11th June 2026

We would like to register our strong objection to Planning Application 2026/62/90880/E for the proposed redevelopment of the agricultural sheds at Liley Hall Farm into residential units.

TITLE
 BUILDING SIX
 PROPOSED FIRST FLOOR
 UNITS 5 & 6

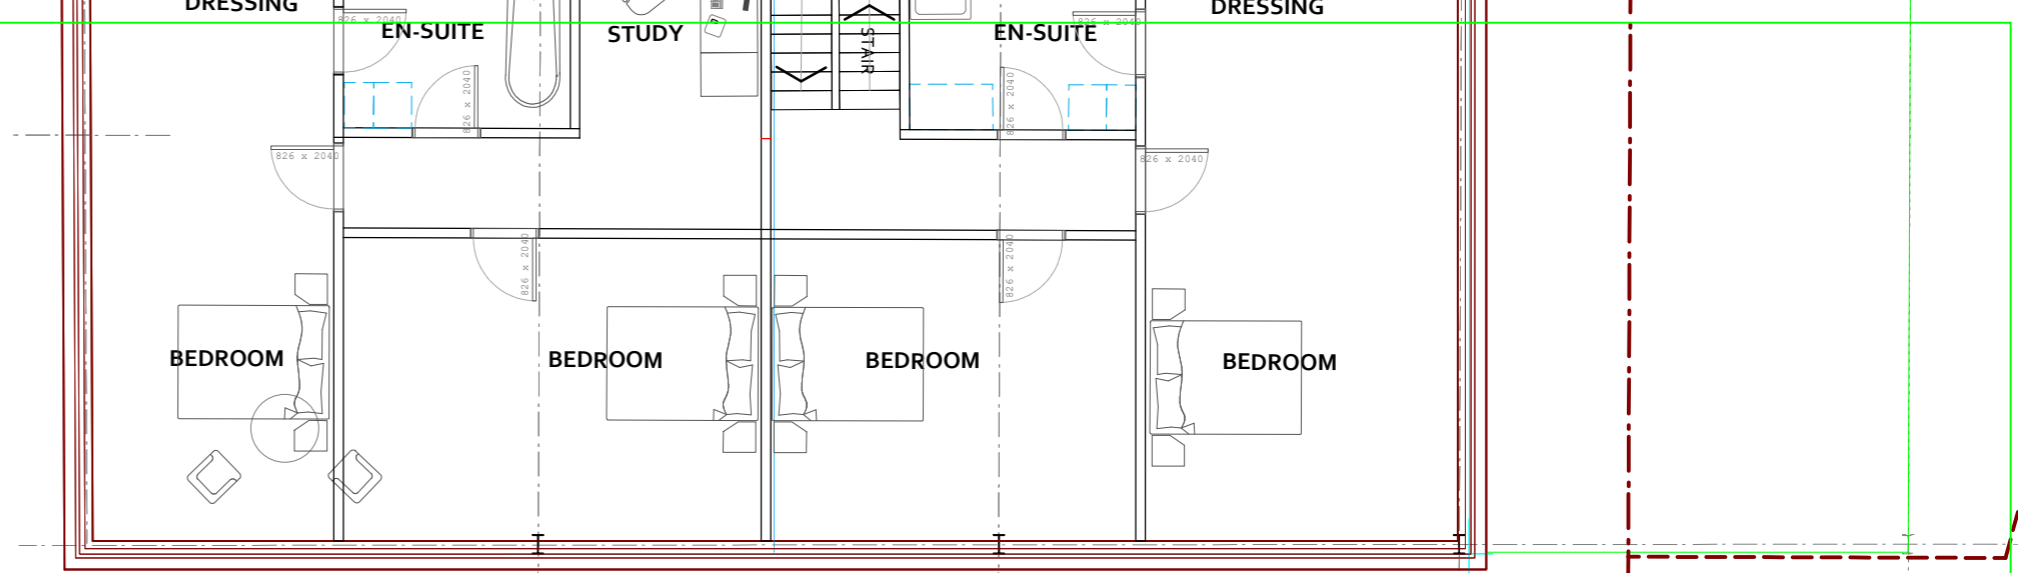
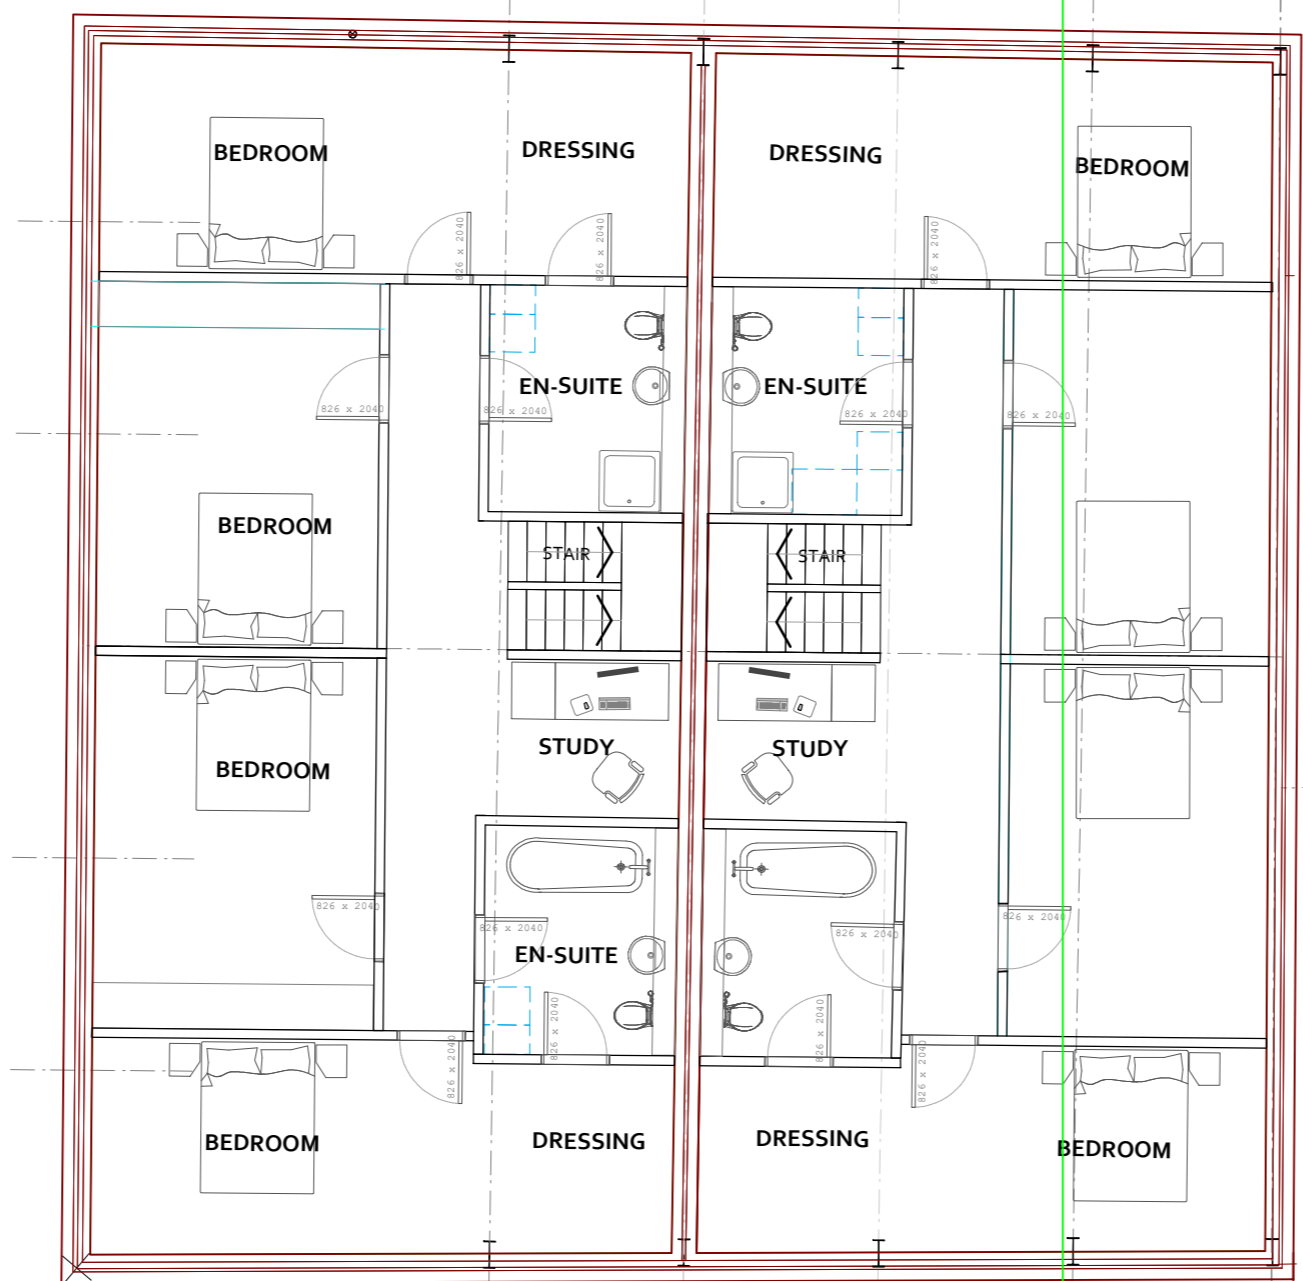
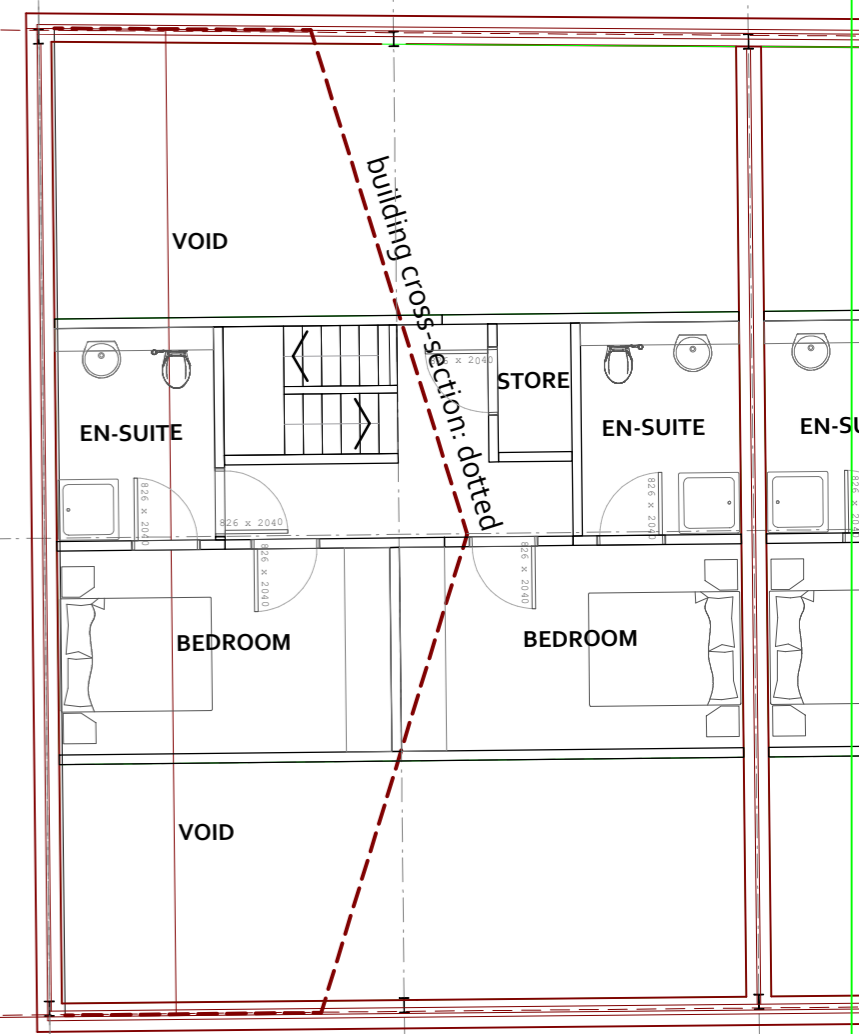
- **Existing Buildings 1-4 (Proposed Unit 1 + Annexe)**
 - Approximately 330sqm for the 5-bed house and 115sqm for the 2-bed annexe
 - Totalling approximately 445sqm (substantially greater than the 150sqm allowed)
- **Existing Building 5 (proposed units 2-4)**
 - Approximately 640sqm for the 3 new dwellings proposed (substantially greater than the 150sqm allowed)
- **Existing Building 6 & 7 (proposed units 5-9)**
 - Approximately 716sqm for the 5 new dwellings proposed (which, when taking into account first floor accommodation, would be *substantially* greater than the 150sqm allowance per unit)
- **Total Built Development Area approximately 1800 sqm**
 - Significantly exceeding the 1000sqm maximum that Class Q stipulates

- We have concerns about how vehicular access is to be achieved to units 6-9 on the far side of the site. It appears that a ring road is proposed around the site, bringing increased traffic directly past the Grade II listed Farmhouse and Hall.
